Reference: 1021096 L02A 600 Woodstock Avenue Glendenning ENV.doc

RE: 600 Woodstock Avenue, Glendenning Response to DPIE comments

Figure 5: LAeq,15min noise contours (Day)

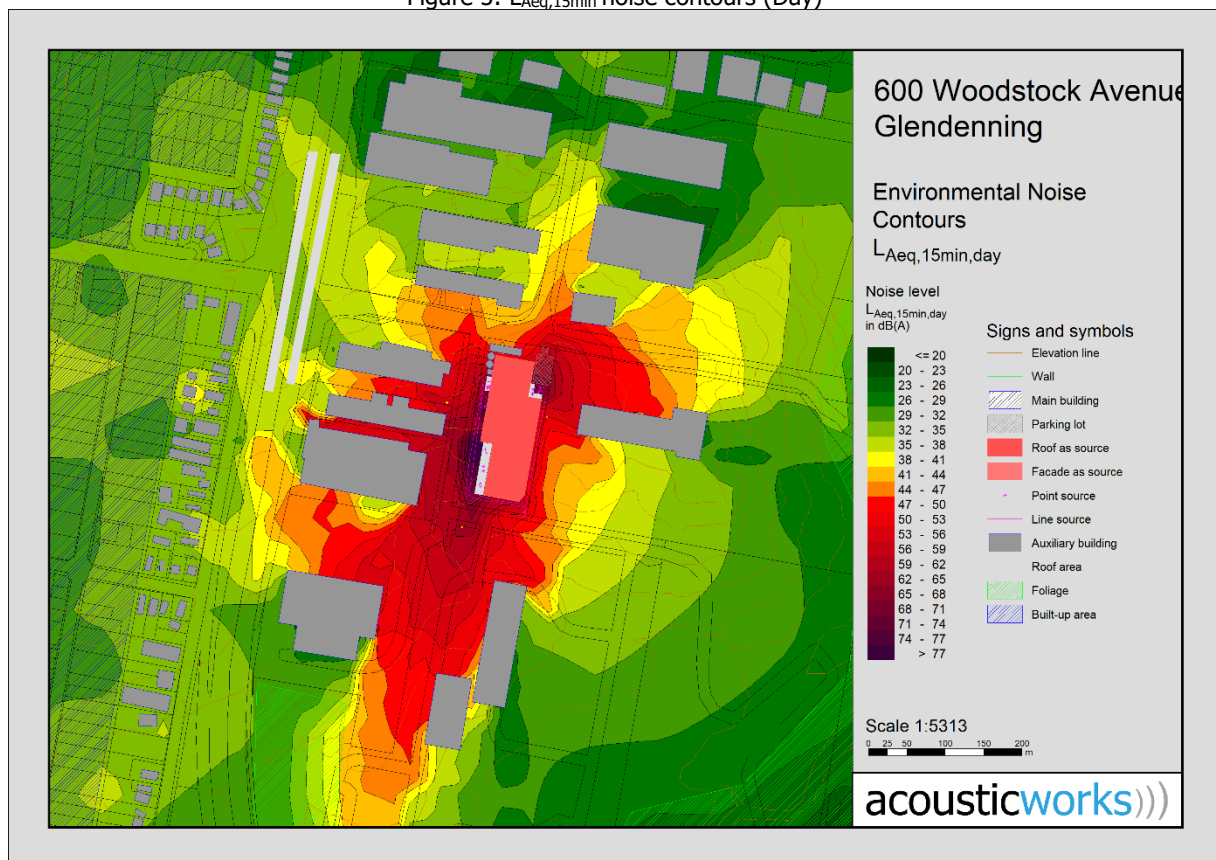
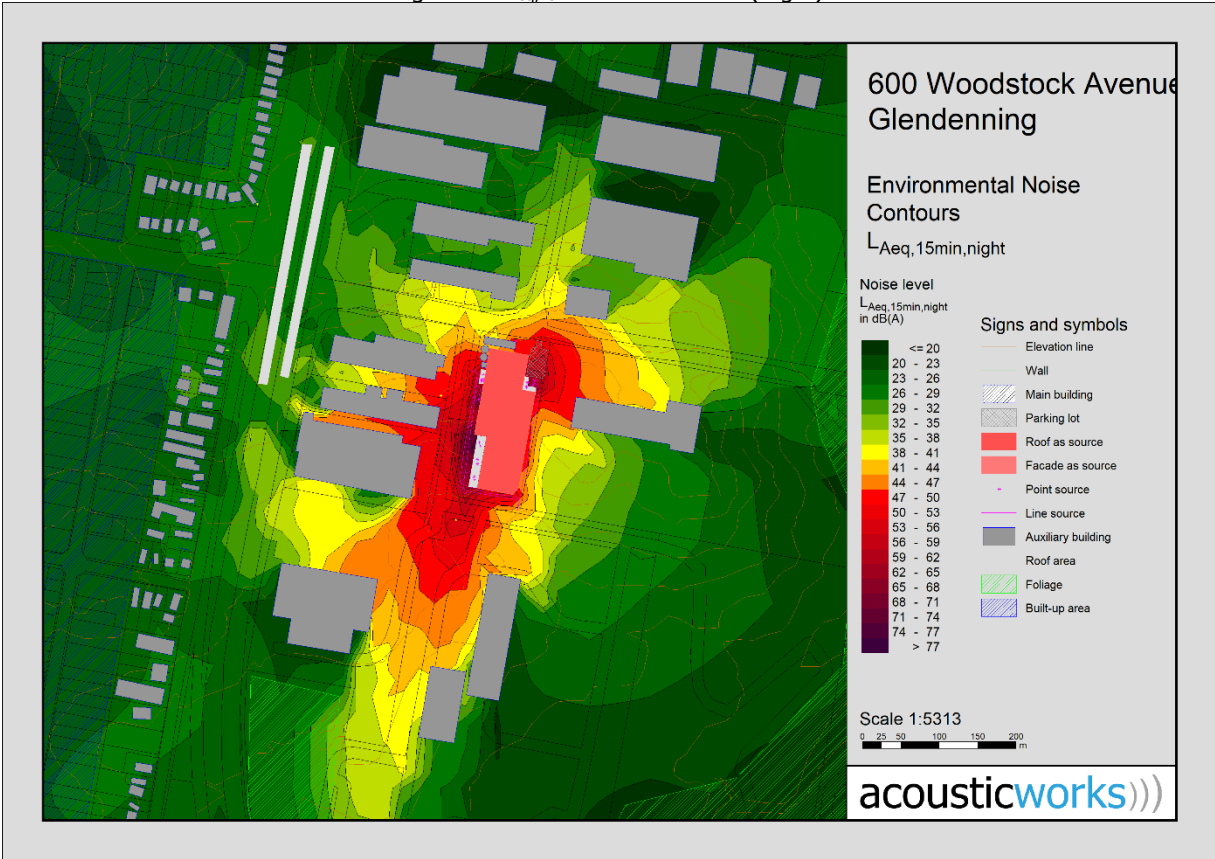
*"24. Confirm trucks idling and manoeuvring within the site have been considered as noise sources and update Section 8.1.1 and Figures 5 and 6 of the NVIA accordingly*

The assessment has been updated to include trucks idling and manoeuvring within the site, with Section 8.1.1, Table 15 and Figures 5 to 7 updated accordingly.
